Application Ref:	3/2025/0362			 <div>Ribble Valley Borough Council</div> <div>www.ribblevalley.gov.uk</div>
Date Inspected:	28/05/2025	Site Notice:	28/05/2025	
Officer:	MC			
DELEGATED ITEM FILE REPORT:				
				REFUSAL

Development Description:	Proposed two storey side extension, modification of an existing window opening to form a new front entrance door, installation of solar panels and air source pump.
Site Address/Location:	The Old Dairy, Whitewell Road, Cow Ark, Clitheroe, BB7 3DG

PROPOSED FLOOR PLANS

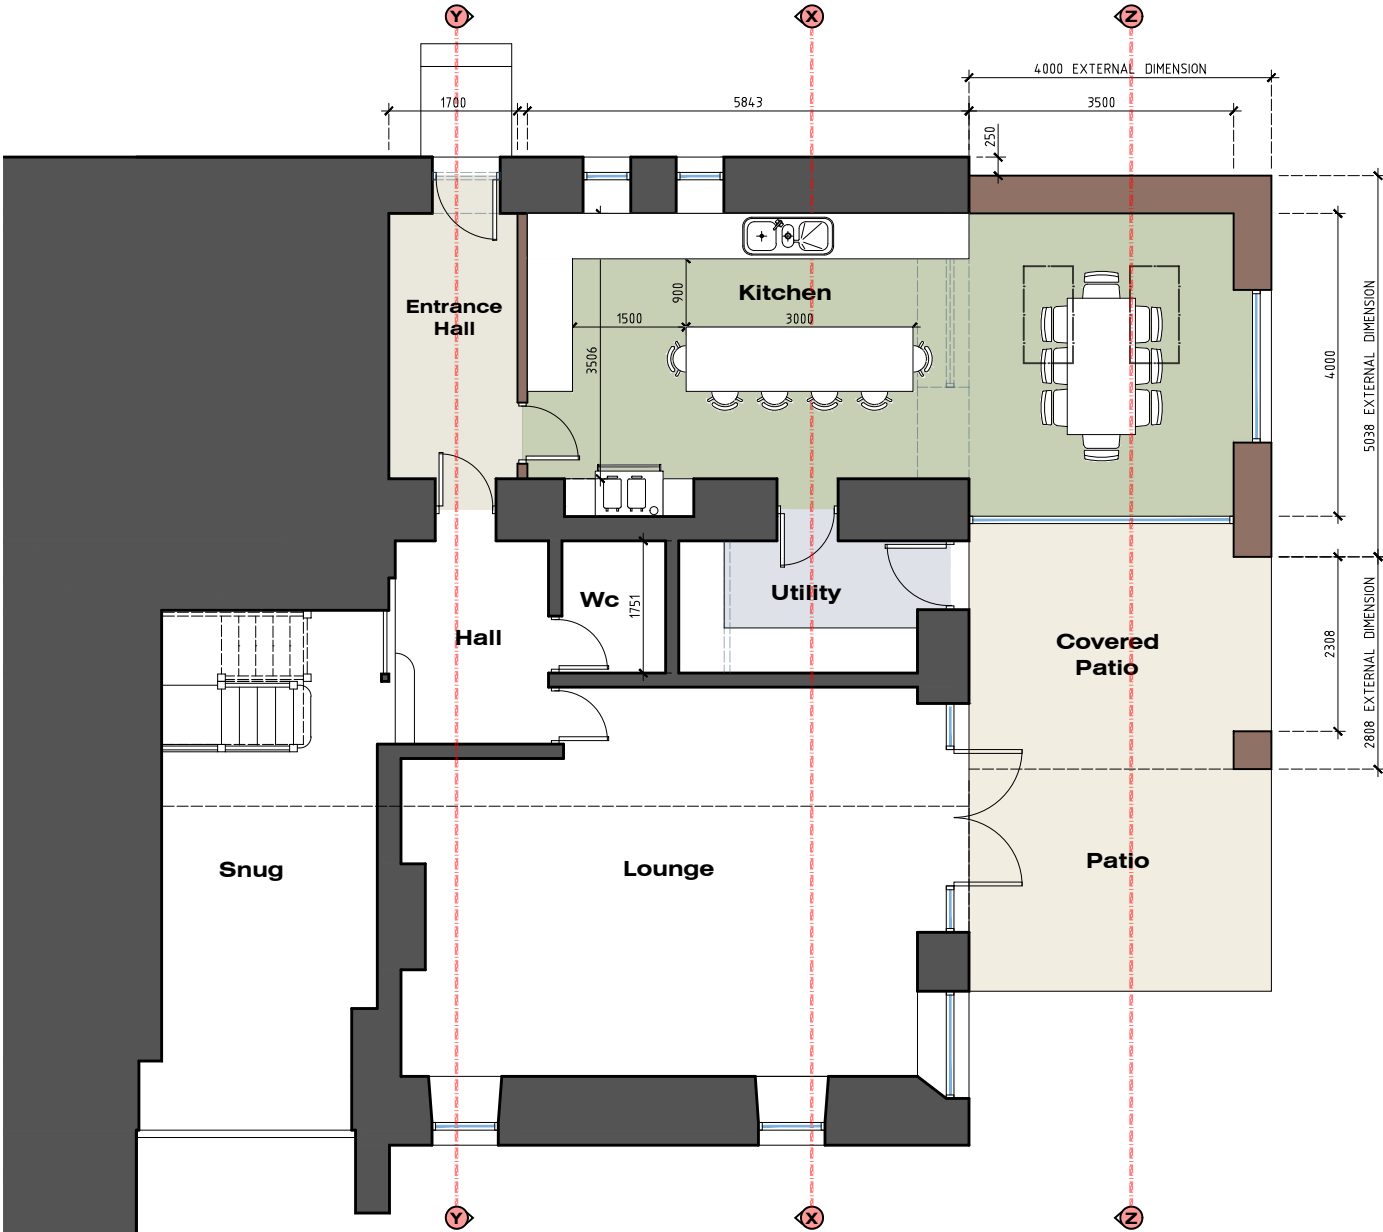
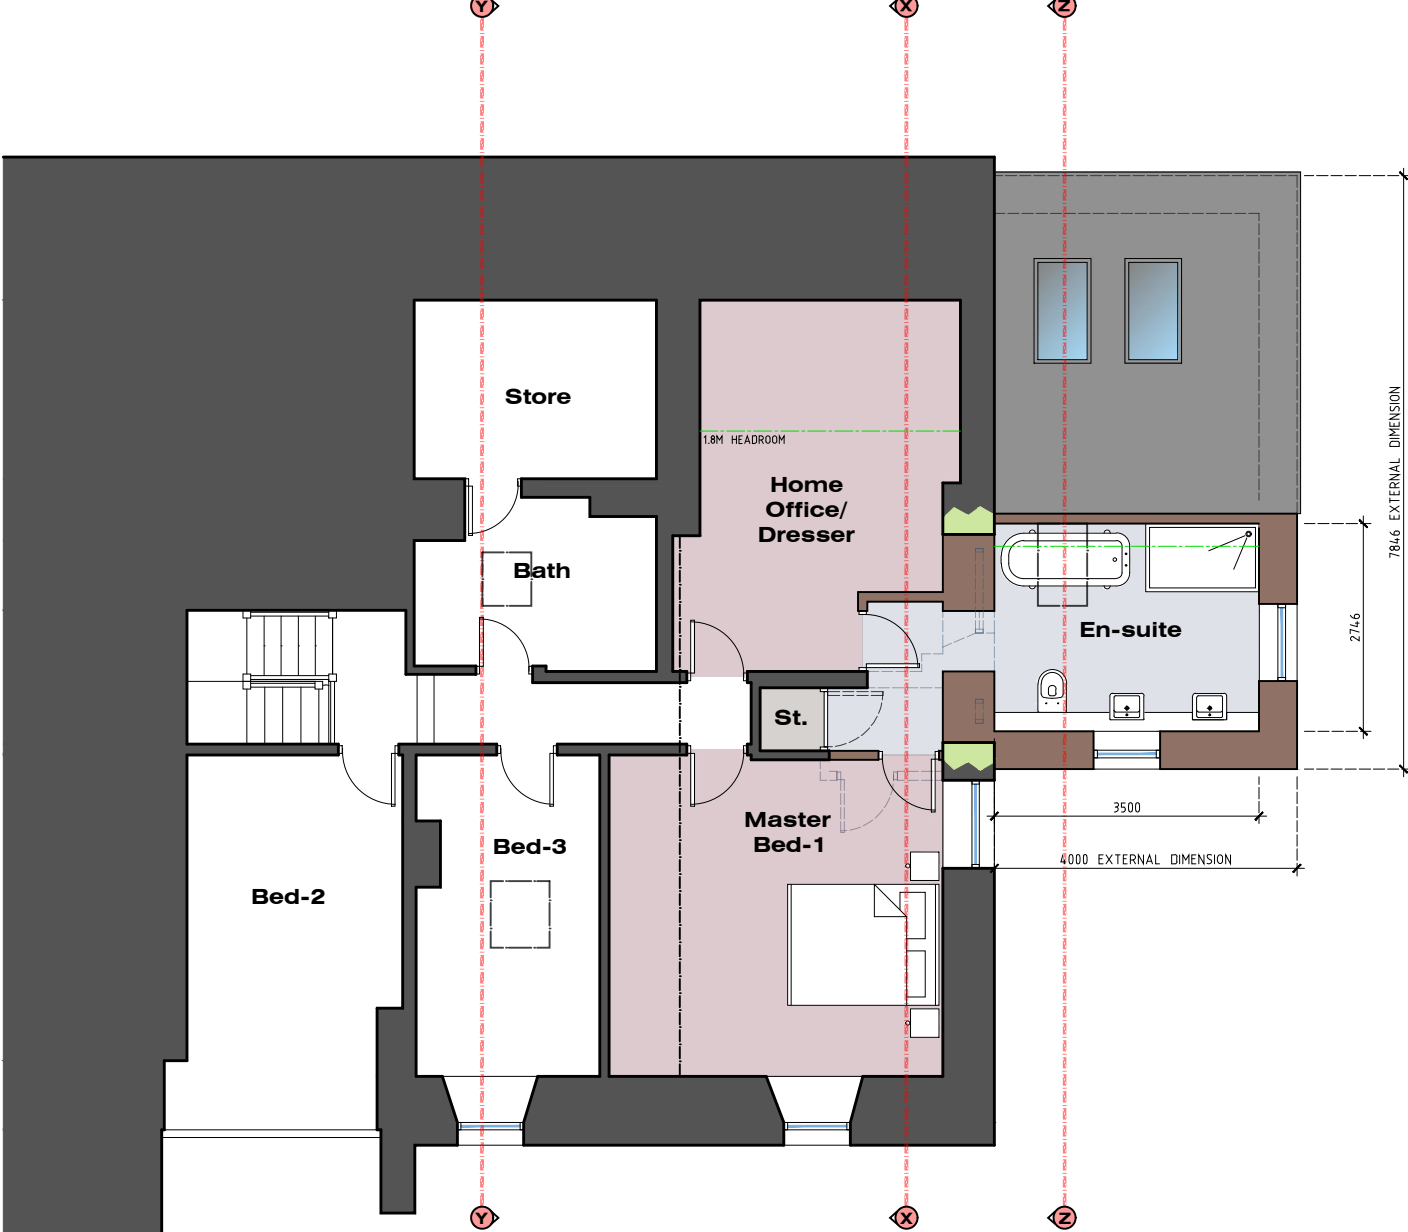
The submitted floorplans indicate that the proposed extension would not increase the number of bedrooms at the property, not would it impact on existing parking arrangements at the site. The Local Highway Authority raise no objection

As such would result in five bedrooms compared to the existing four bedrooms. The submitted floorplans also indicate that there would be one parking space for the property within the existing garage, although this does

appear to be smaller than a standard parking size. Notwithstanding this, the driveway could accommodate parking for up to three vehicles which is considered to be acceptable.
